**Item No.** Report of the Head of Development Management and Building Control

**Address:** 65 SUMMERHOUSE LANE HARMONDSWORTH

**Development:** Part-retrospective application for the erection of outbuilding to rear garden (amended description)

**LBH Ref Nos:** 47333/APP/2023/1509

SITE: 6 SUMMERHOUSE LANE,
HARMONDSWORTH, UB7 0AW
BLOCK PLAN: 1:500

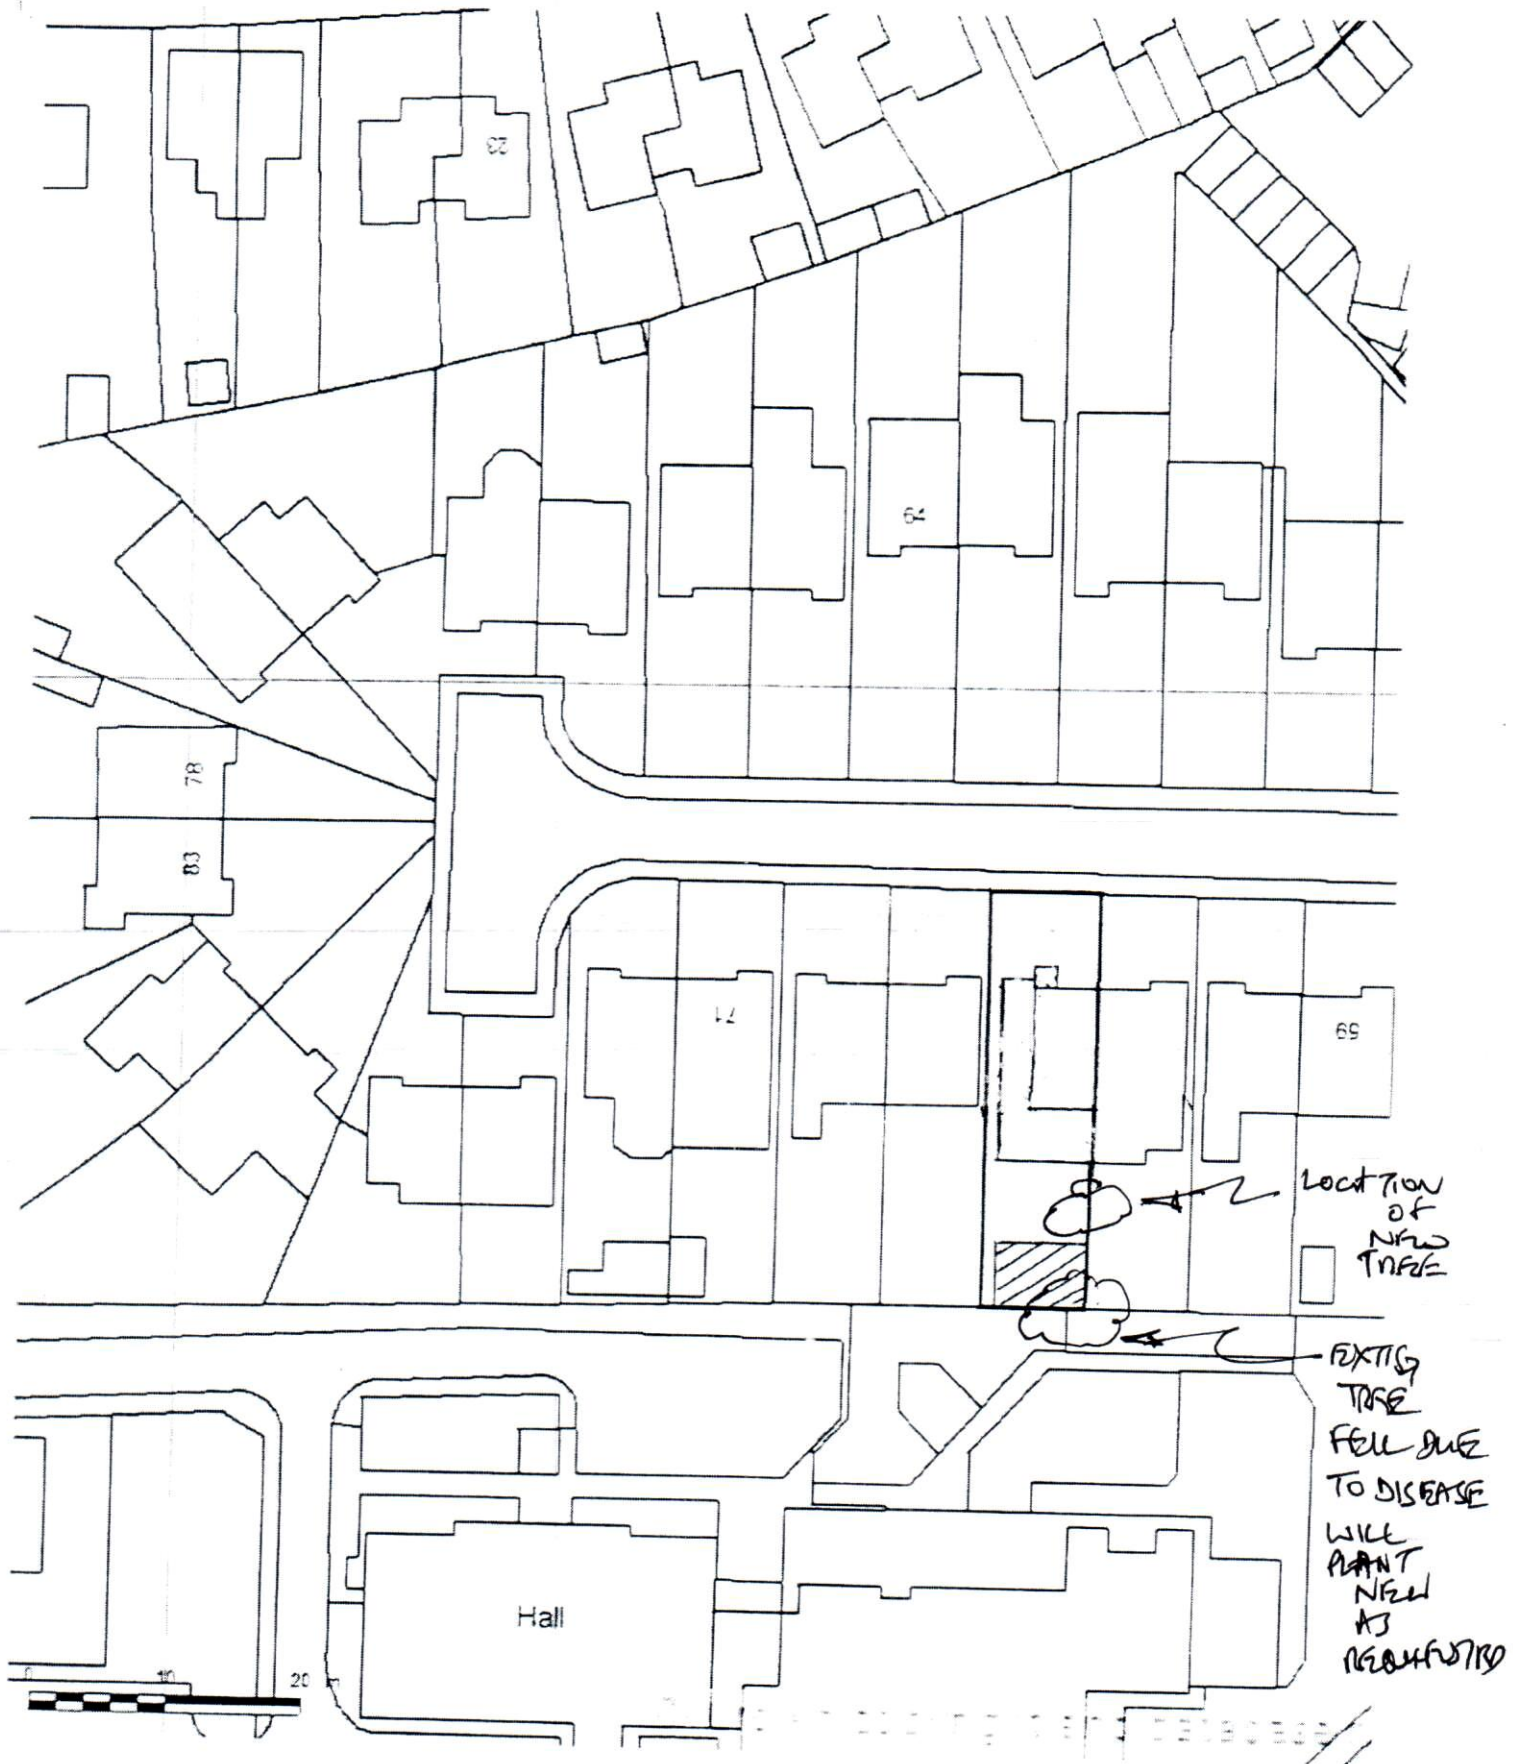
Despite its policy compliant footprint, it is considered that when viewed and considered in combination with the approved extensions (which are under construction), the development would result in an overdevelopment of the site. Limited space would exist between the rear wall of the outbuilding and the rear wall of the approved extensions making the site appear cramped and congested. The resulting rear garden would be filled with development, contrasting with other

gardens in the area, which are generally green and open. Due to its height, footprint and location within a small plot the building would appear oversized. Additionally, outbuildings within the area are generally smaller, as such the one proposed would be out of character in terms of its size.

Approximately 42 sqm of useable rear garden will be retained. Table 5.3 (Private Outdoor Amenity Space Standards) of the Hillingdon Local Plan Part 2: Development Management Policies (2020). States that 2 and 3 bedroom properties should have a minimum of 60sqm of private amenity space. Inadequate private amenity space would be retained for occupiers of the existing dwelling therefore not complying with Policy DMHB 18 of the Hillingdon Local Plan Part 2: Development Management Policies (2020). The substandard amount of amenity space would also be cramped and congested with tall buildings, limiting outlook from the space and making it feel congested. The resulting undersized garden also adds to the conclusion that the site would be visually cramped.

Due to its height, scale, bulk, close proximity to the site's boundaries and close proximity to the extended host dwelling, the proposed outbuilding would result in a overdevelopment of the site. The resulting site would appear cramped and out of character with surrounding sites which are generally spacious and free of this amount of development. The outbuilding would be oversized when compared with others within the area. Furthermore the development has been facilitated by the removal of a protected tree which contributed to the character and appearance of the site and area. The loss of the tree has caused harm to the character and appearance of the site and area. The proposed development is therefore considered to have an adverse impact on the visual amenities of the host dwelling, site, surrounding area and Conservation Area. The development conflicts with Policy BE1 of the Hillingdon Local Plan: Part One - Strategic Policies (November 2012), and Policies DMHB 1, DMHB 4, DMHB 11, DMHB 12 and DMHD 2 of the Hillingdon Local Plan: Part 2 - Development Management Policies (January 2020), Policy D3 of the London Plan as well as paragraph 130 of the NPPF (2021).

Due to its height, scale, bulk, close proximity to the site's boundaries and close proximity to the extended host dwelling, the proposed outbuilding would result in the rear garden of the host dwelling being cramped and of substandard size. The resulting rear garden would provide existing and future residents of 65 Summerhouse Lane with a poor standard of external living accommodation to the detriment of their amenities. As such, the proposal would be contrary to Policy BE1 of the Hillingdon Local Plan: Part One Strategic Policies (2012) and Policies DMHB 11 and DMHB 18 of the Hillingdon Local Plan: Part Two - Development Management Policies (2020), as well as paragraph 130 (f) of the NPPF (2021).

Location for new silver birch tree:

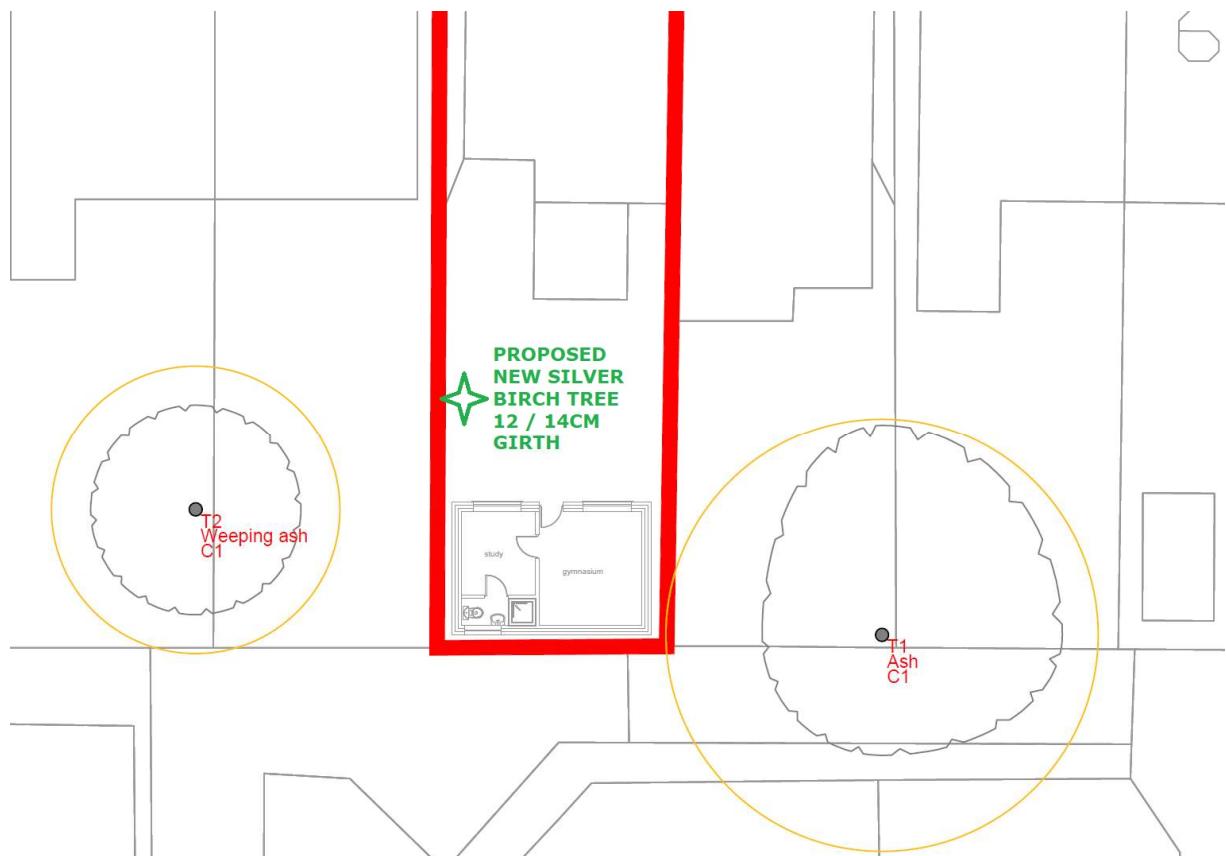
A large tree once existed to the rear of the site. The applicant has suggested that the tree fell/was removed due to disease. As mentioned above, no tree survey was submitted to substantiate the claim. No plan has been submitted showing the location of a replacement tree. Nor does there appear to be space on site, so that a replacement tree could be secured via condition. It is therefore considered (at this stage) that the loss/removal of the tree is unjustified, unacceptable and harmful to the character and appearance of the site, area and Conservation Area (as expanded on earlier in the report).

The proposed development would be facilitated by the unjustified removal of a protected tree within the Harmondsworth Village Conservation Area. Insufficient information has been submitted to justify the removal of the tree. No tree replacement plan has been submitted to mitigate the loss of the tree. The loss of the tree has caused harm to the character and appearance of the site and Conservation Area. The proposed development is therefore contrary to Policy BE1 of the Hillingdon Local Plan: Part One - Strategic Policies (November 2012), Policies DMHB 1, DMHB 4, DMHB 11, DMHB 12 and DMHB 14 of the Hillingdon Local Plan: Part 2 - Development Management Policies (January 2020), Policy D3 and G7 of the London Plan and paragraph 131 of the NPPF (2021).
